# CITY OF ALBUQUERQUE

**Re: International District Library**  
**7667 Central Ave NE**  
**30-Day Temporary Certificate of Occupancy**  
**Transportation Development Final Inspection**  
Engineer's/Architect's Stamp dated 1-23-20 (K19D005)  
Certification dated 11-30-21

Based upon the information provided in your submittal received 12-1-20, Transportation Development has no objection to a 30-day Temporary Certificate of Occupancy based. This letter serves as a "green tag" from Transportation Development for a 30-day Temporary Certificate of Occupancy to be issued by the Building and Safety Division.

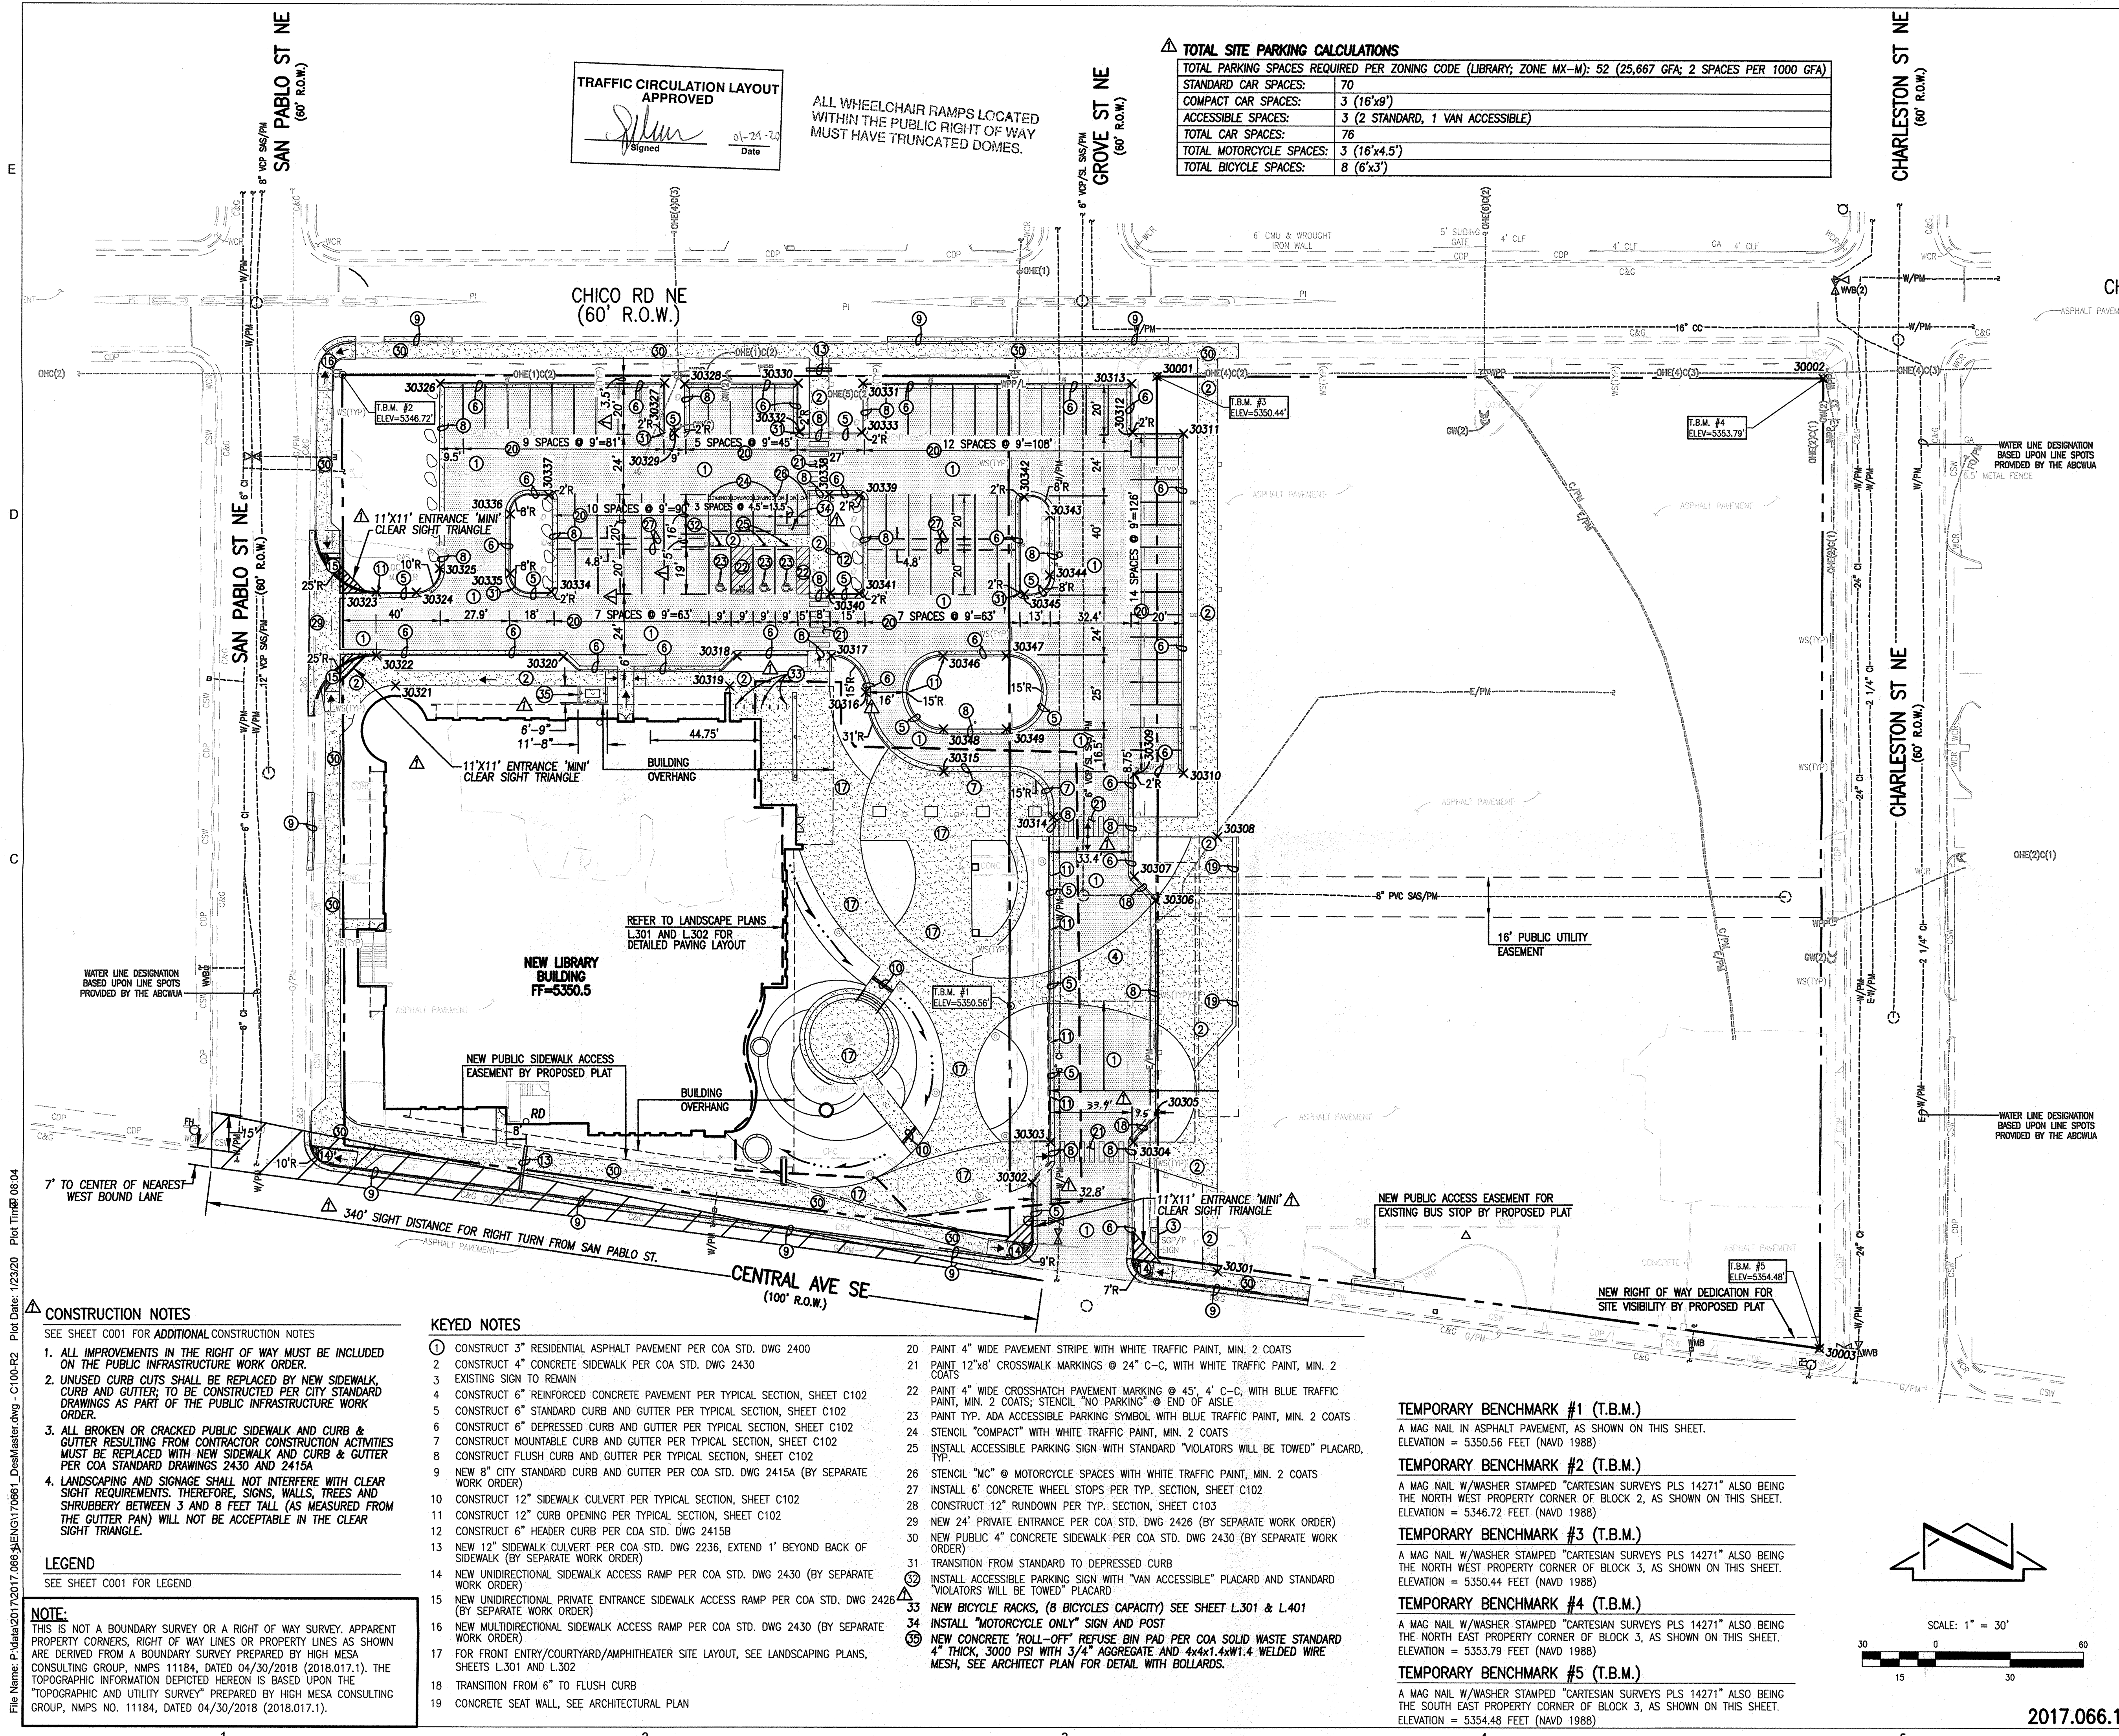
- The placements of some parking bumpers have turned the standard size parking stalls into compact parking spaces. Please push back the parking bumpers.
- Remove security fence, portable building, trash container, porta potties, construction equipment and debris from site.
